Your Application ref:  
2530-TDWAY-TTTUN-990-ZZ-CO-700187

Date: 14 August 2020

**THE THAMES WATER UTILITIES LIMITED (THAMES TIDEWAY TUNNEL) ORDER (SI 2014/2384) (“the 2014 Order”) AS AMENDED BY THE THAMES WATER UTILITIES LIMITED (THAMES TIDEWAY TUNNEL) (CORRECTION) ORDER (SI 2015/723), THE THAMES WATER UTILITIES LIMITED (THAMES TIDEWAY TUNNEL) (AMENDMENT) ORDER (SI 2017/659), THE THAMES WATER UTILITIES LIMITED (THAMES TIDEWAY TUNNEL) (AMENDMENT) ORDER (SI 2018/1262), THE THAMES WATER UTILITIES LIMITED (THAMES TIDEWAY TUNNEL) (AMENDMENT) ORDER (SI 2020/268), AND THE NOTICE OF VARIATION No. 1 (17 MARCH 2015) AND NOTICE OF VARIATION No. 2 (17 AUGUST 2017) TO THE DEEMED MARINE LICENCE.**

**Application for a non-material change in relation to the Victoria Embankment Foreshore (VCTEF) and Blackfriars Bridge Foreshore (BLABF) sites.**

Document Information
Application for Development Consent
Extent of loss of listed river wall
Sheet 2 of 2
Book of plans - section 19
DCO-PP-17X-BLABF-190023
January 2013

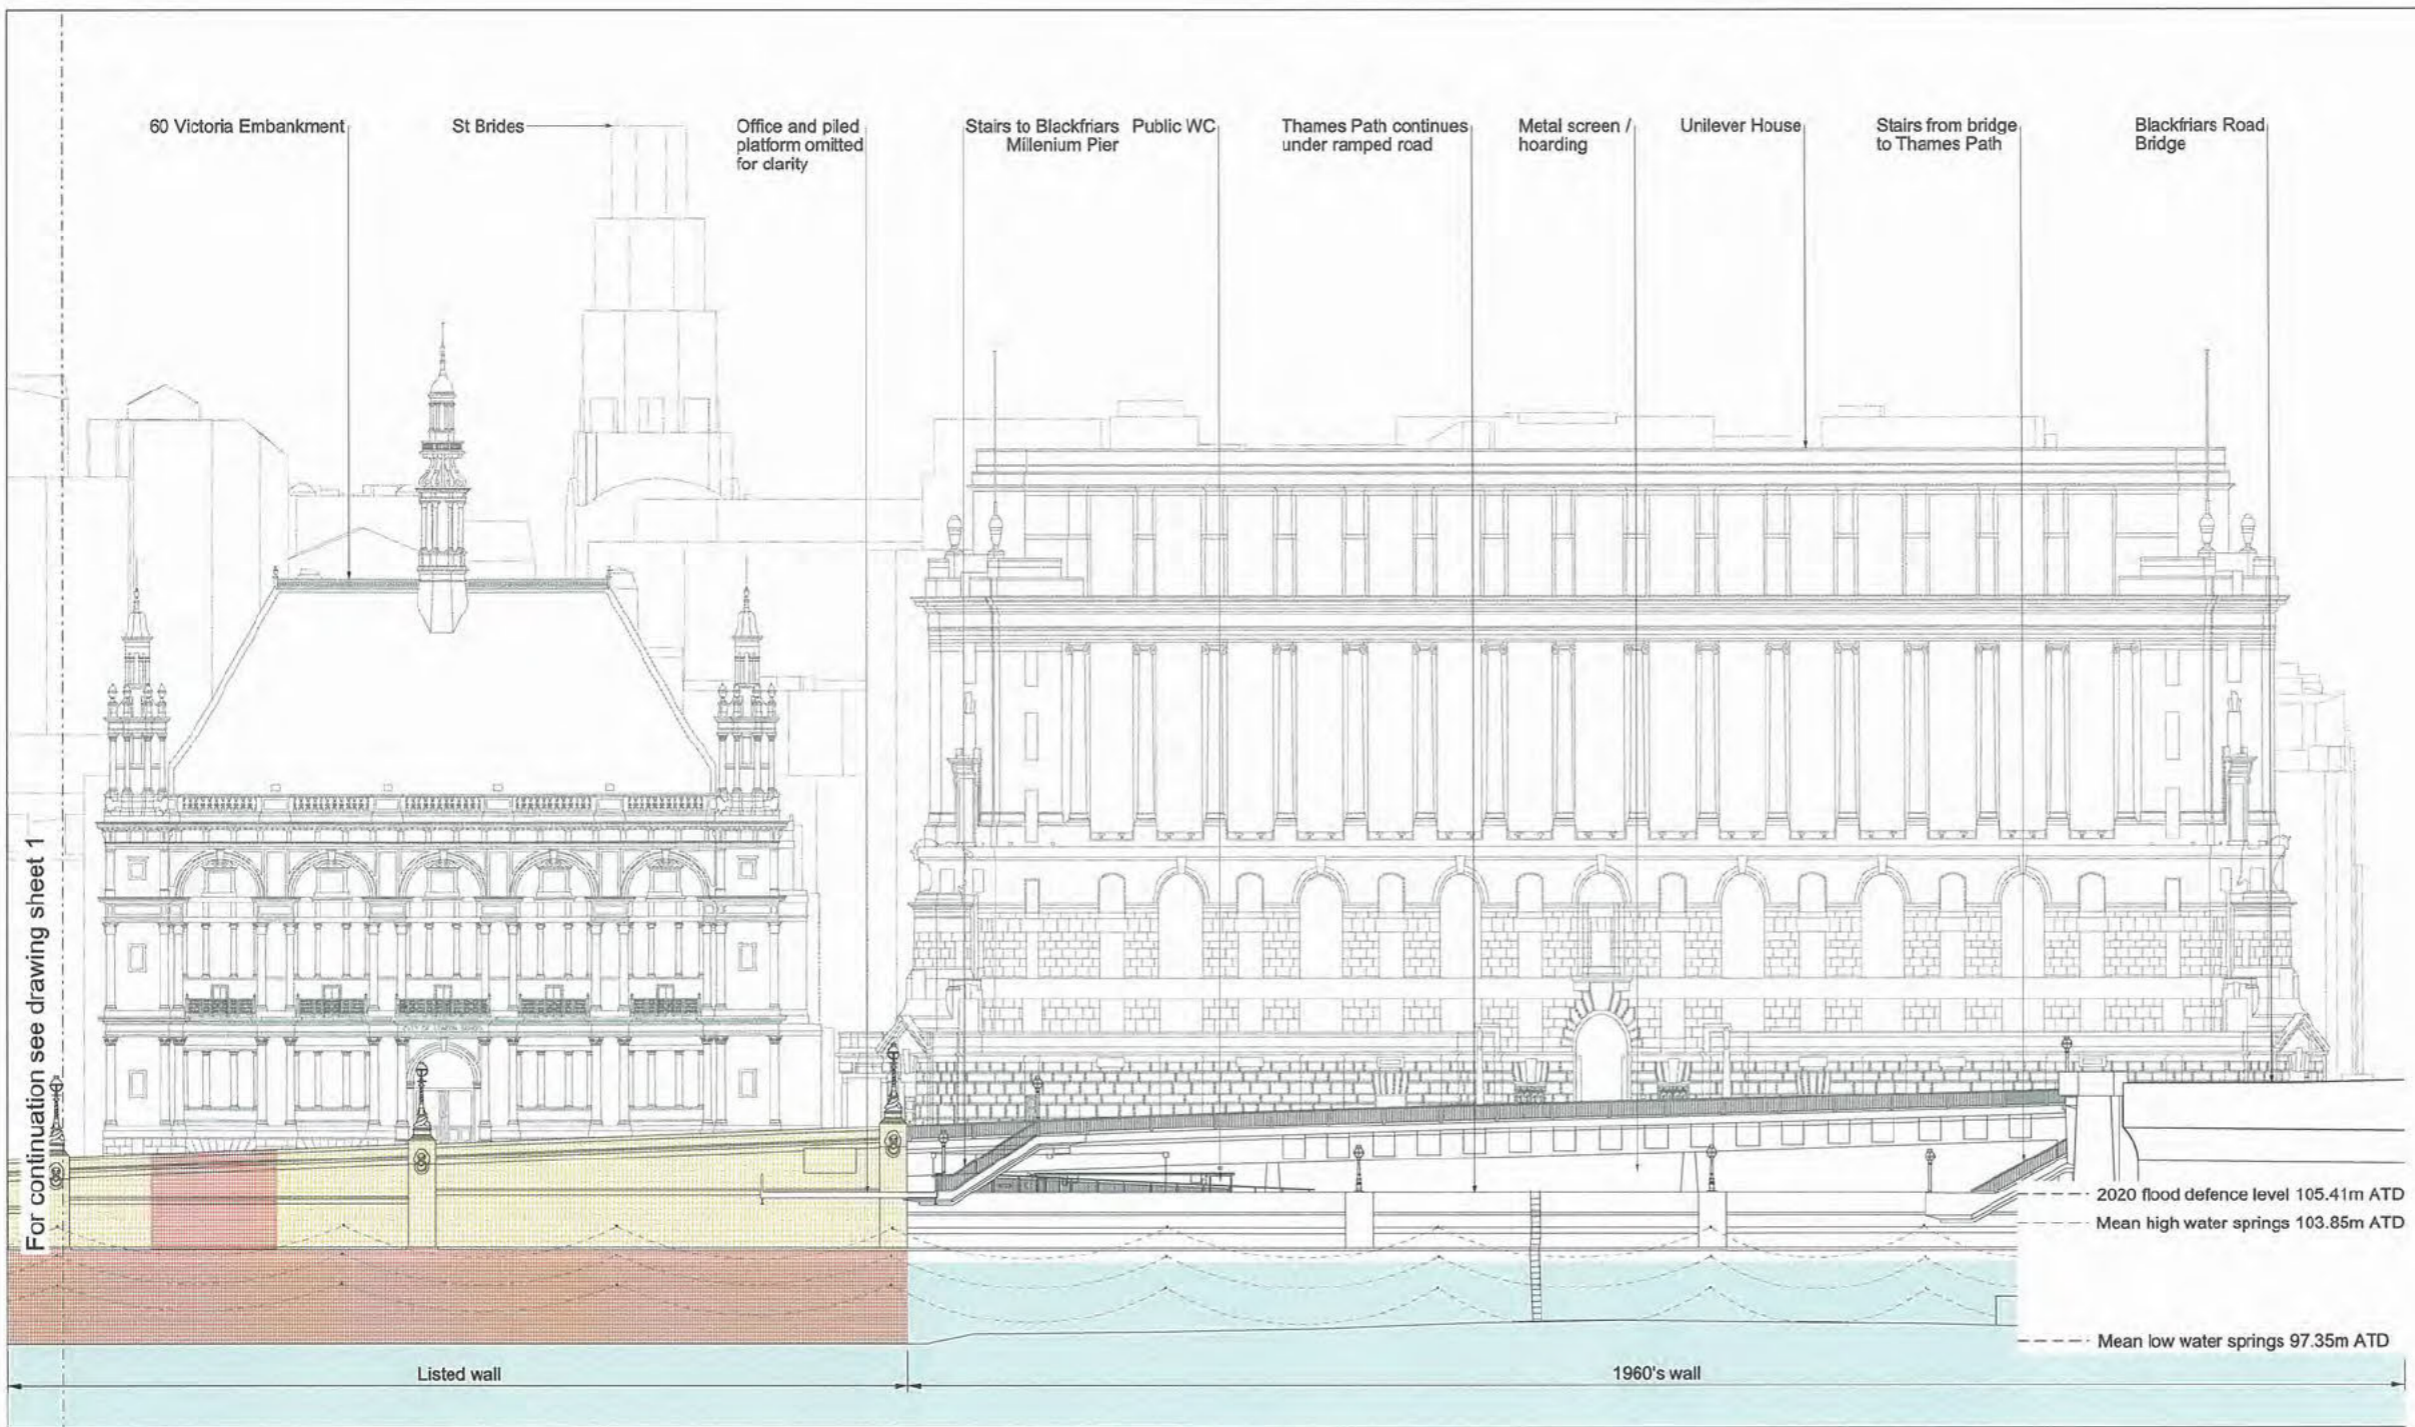
- b. Amendments to the Extent of loss of listed river wall plan (drawing DCO-PP-17X-BLABF-190023) to allow for the permanent loss of the listed structure above the level of the Low-Level Sewer No 1 interception, and related revision to the plan reference in the DCO.

- c. Addition of an informative note to Extent of loss of listed river wall plans at BLABF (drawings DCO-PP-17X-BLABF-190022-rev 1 and DCO-PP-17XBLABF-190023) to make it clear that the permanent loss of the listed river wall authorised under the DCO extends to the toe of the river wall.

Drawing file: WW010001 / WW010001-006138-DCO-PP-16X-VCTEF-180008_Rev4_A3__Authorised.pdf

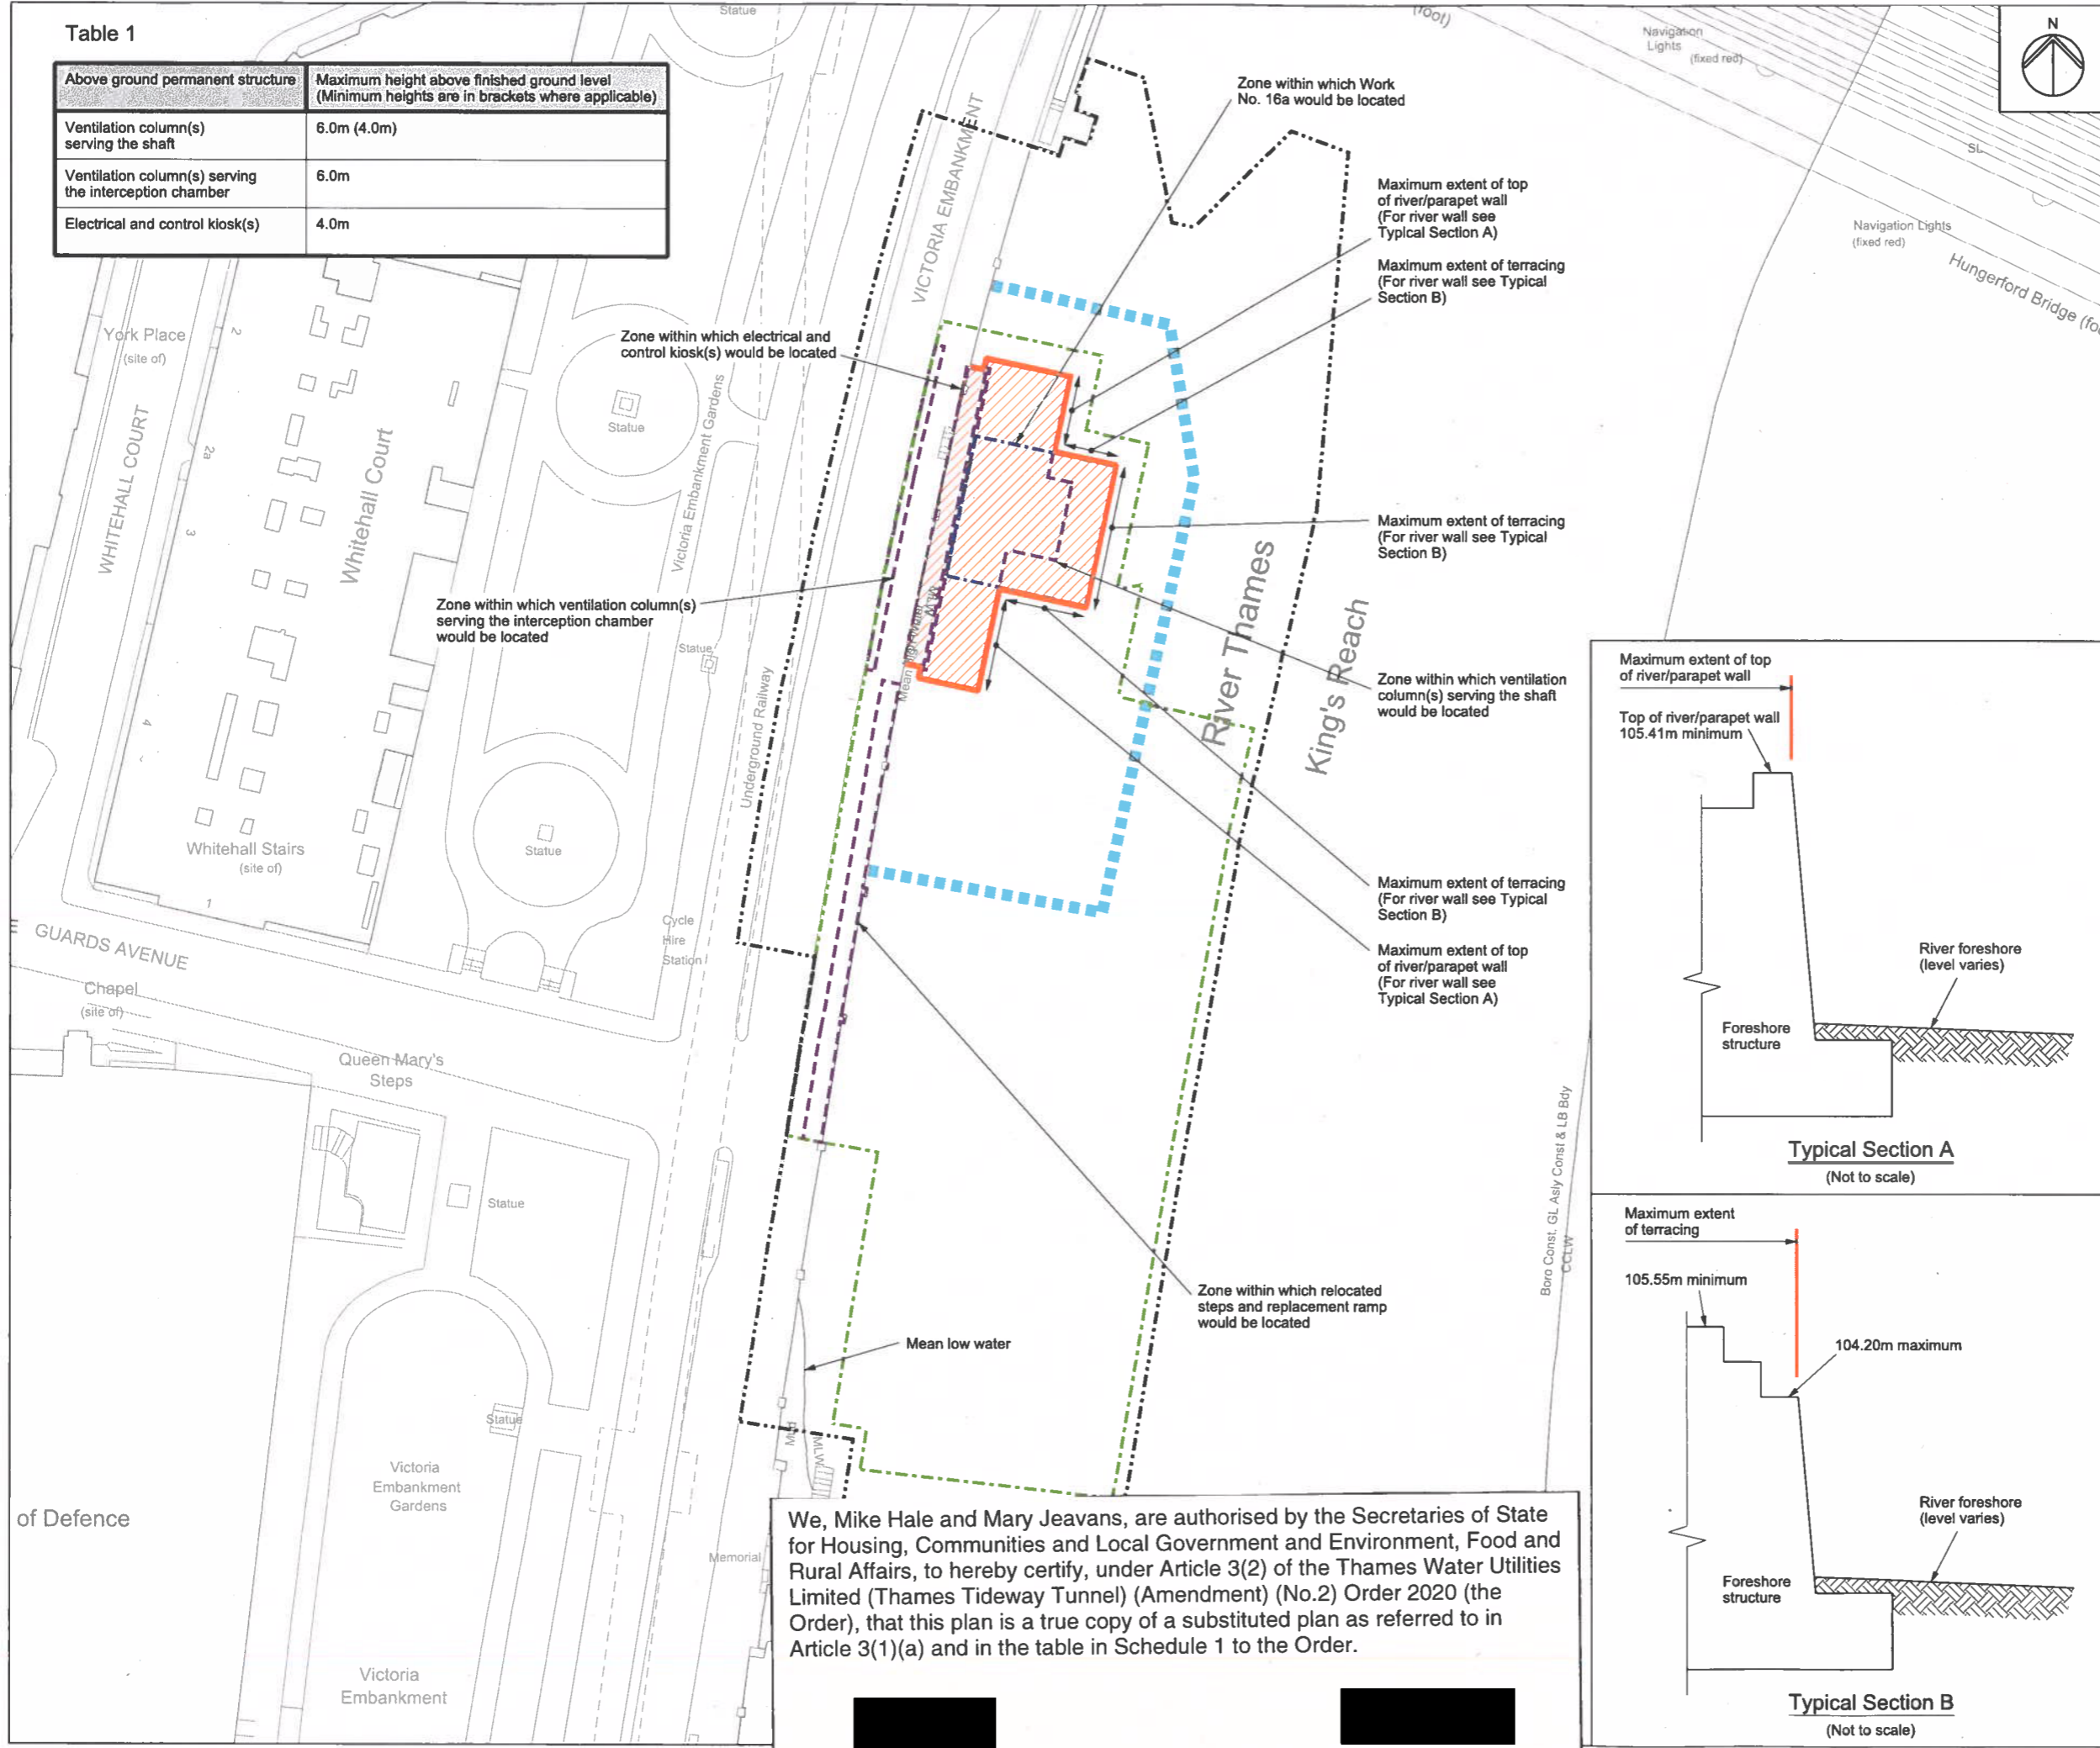
- a. Amendments to the Site works parameter plan (Drawing DCO-PP-16X-VCTEF-180008-rev 3) so that the shaft parameter within the site is expanded slightly westwards to match the actual shaft construction works approved by

the DCO. There are no changes to the size and location of the shaft on the ground within the site. The revised drawing (DCO-PP-16X-VCTEF-180008-rev 4) shows the amended shaft parameter.
